From: Simon Davis
Sent: 31 March 2017 12:21
To: Planning.Responses
Subject: FW: Land adj No2 North Bersted St
Importance: High

Land adjacent to 2 North Bersted St. Bognor Regis.

Further arguments demonstrating acceptable proposals in relation to the existing off site trees.

SITE PLAN
SCALE 1:200

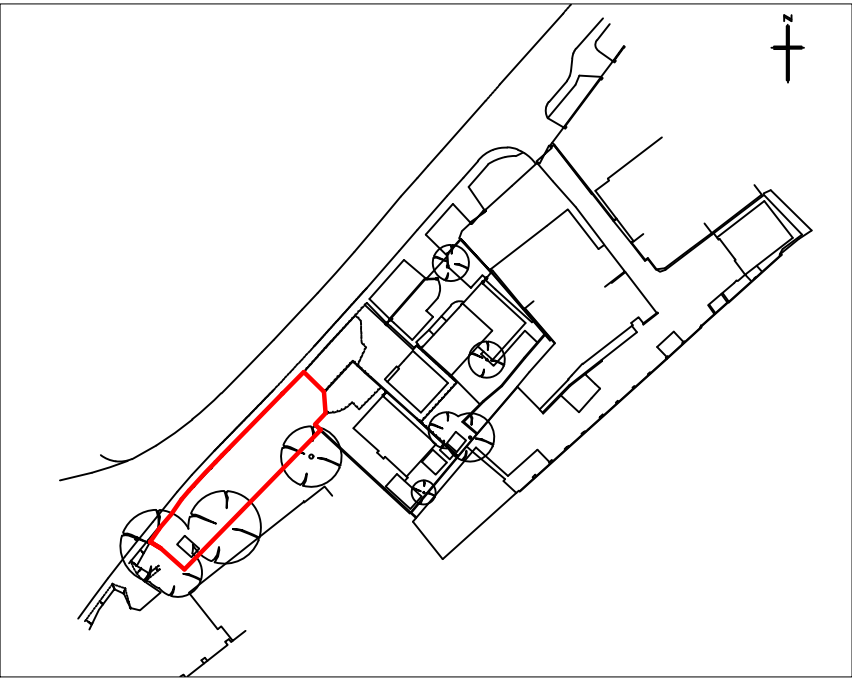
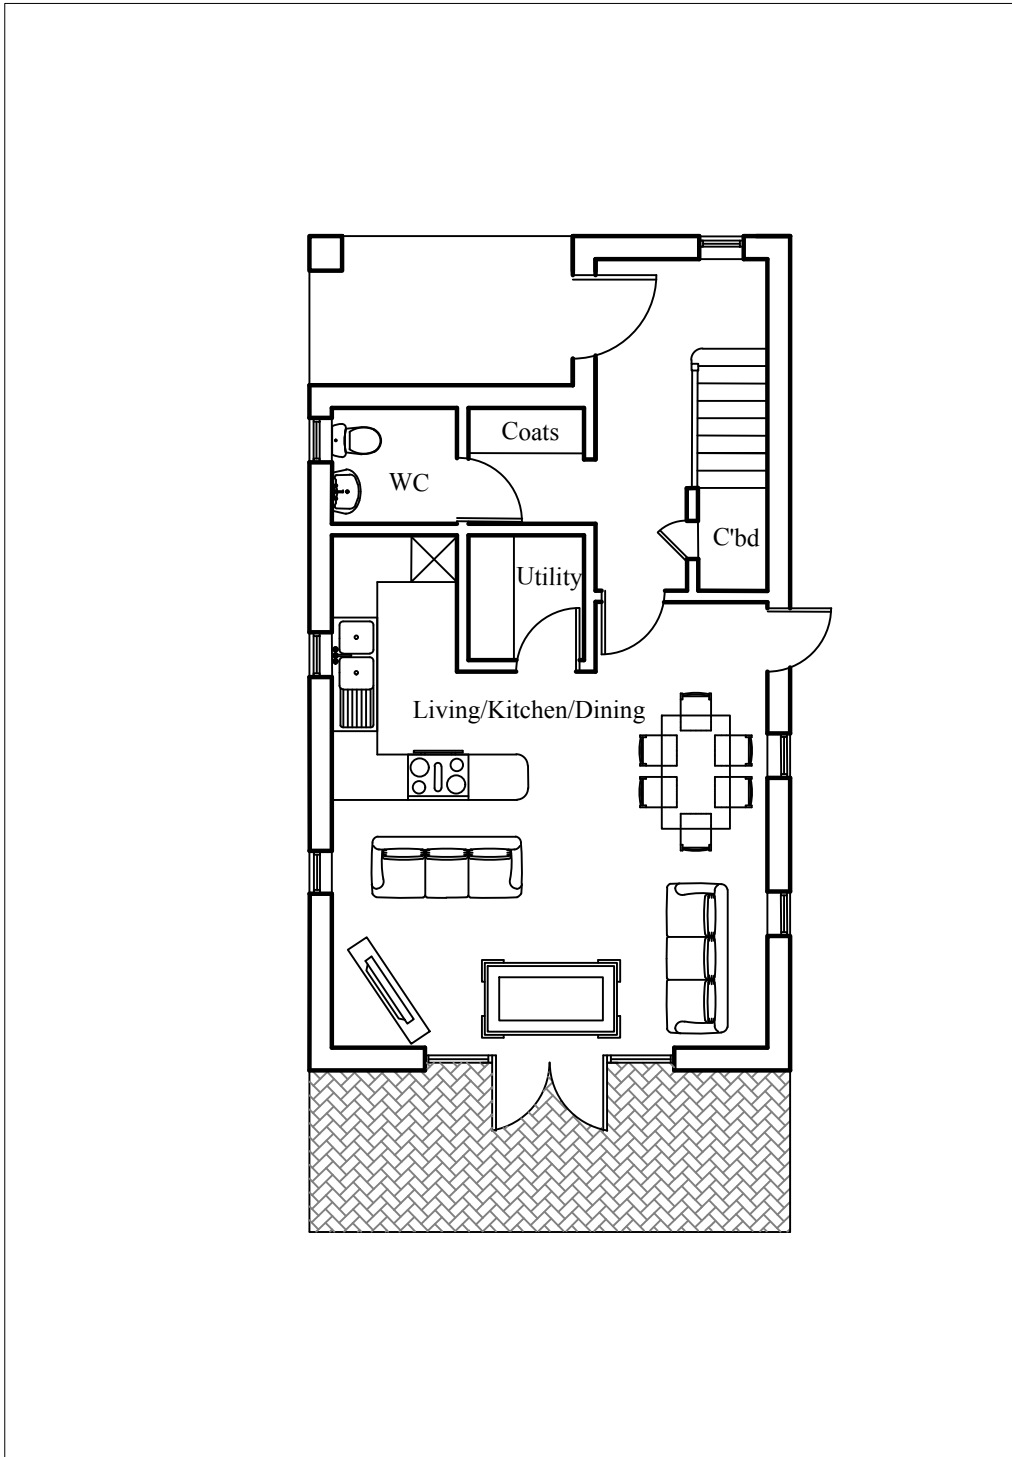
- The proposed dwelling has been set back by circa 1m from back of footpath.
- We would be very happy to put forward alternative elevational treatments to North Bersted Street. The reason we have not done so previously was because of concerns over possible overlooking, which does not appear to be an issue.

Tree Constraints Plan
North Bersted Street, North Bersted, Bognor Regis

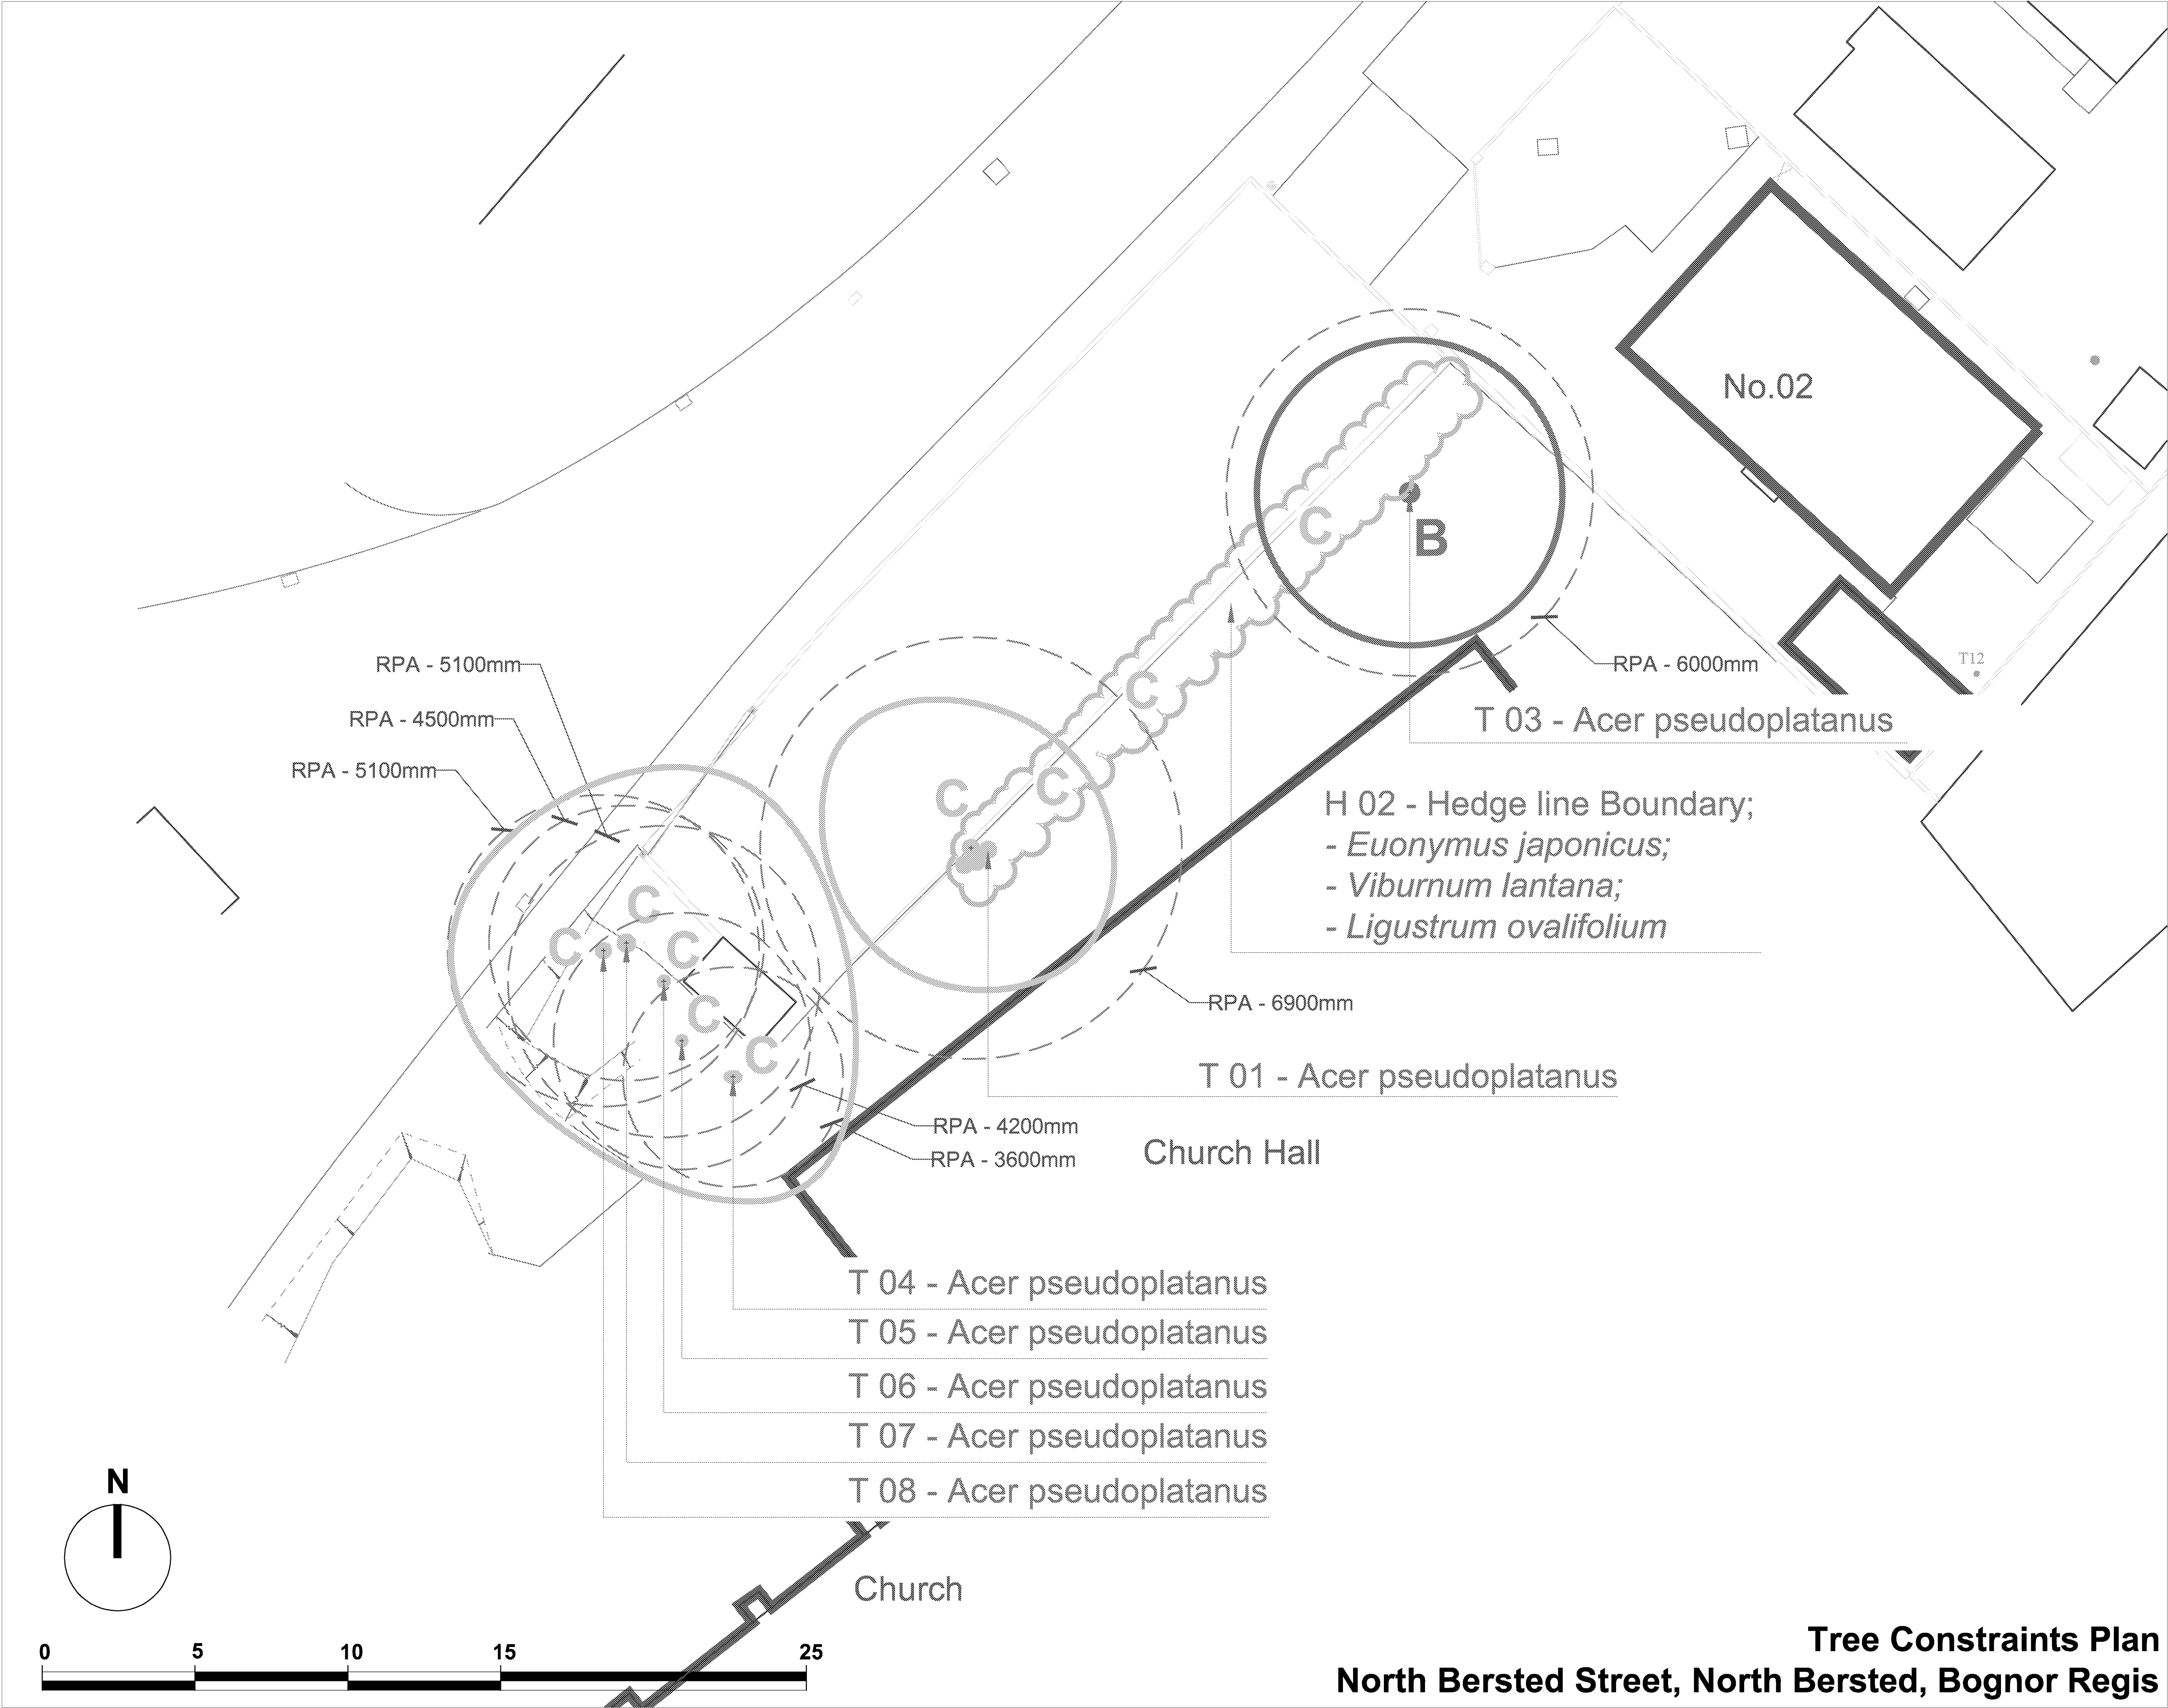
With regards the issue of the trees, my clients wish to make it perfectly clear, that they are not looking to carry out any works to the trees adjacent & apologise if the Landscape Architect has given that impression. Please find attached our response to this item, for your consideration.

The self-seeded sycamores in question are located beyond the site boundary, are not quality trees and are not protected by TPOs. The applicants could, tomorrow if they wished, trim all overhanging branches back to the boundary line entirely legally. Therefore, to refuse planning permission on the grounds that, in the future someone may wish to do something that is entirely legal and does not require planning permission is clearly not a valid reason for a refusal and the applicants have indicated that they would appeal if this was a reason given for such a refusal. The fact that they don't carry out such trimming now demonstrates that they are as keen as others for the trees to remain.

If, in the future, anyone based at the application site did wish to have the trees felled, the fact that they are not in control of the applicant means that such pressure can have no effect. The church, whose land they are located on, have already indicated that they wish the trees to remain.

The supplementary picture of the south east edge of the as site posted on the planning portal (enc below) demonstrates how the low eaves building proposed can be constructed without trimming the trees. The proposed building overlaps the furthest extent of the canopy of one tree by about 1M but, as can be seen from the photograph, the tree in question has a base some 750mm above the FFL of the proposed building and has a tall and ragged canopy. The eaves of the proposed building will easily fit below the plastic bag shown caught in the canopy meaning that no trimming will be required.

The planning issues have to be judged on the situation as it is presented now. The applicants have demonstrated that a perfectly acceptable property, complete with south facing garden can be constructed without "Pressure to fell or prune the off-site trees" now or in the future. Planning guidance does not require gardens to be in full sun or to be so remote from existing trees that gutter protection is not required.
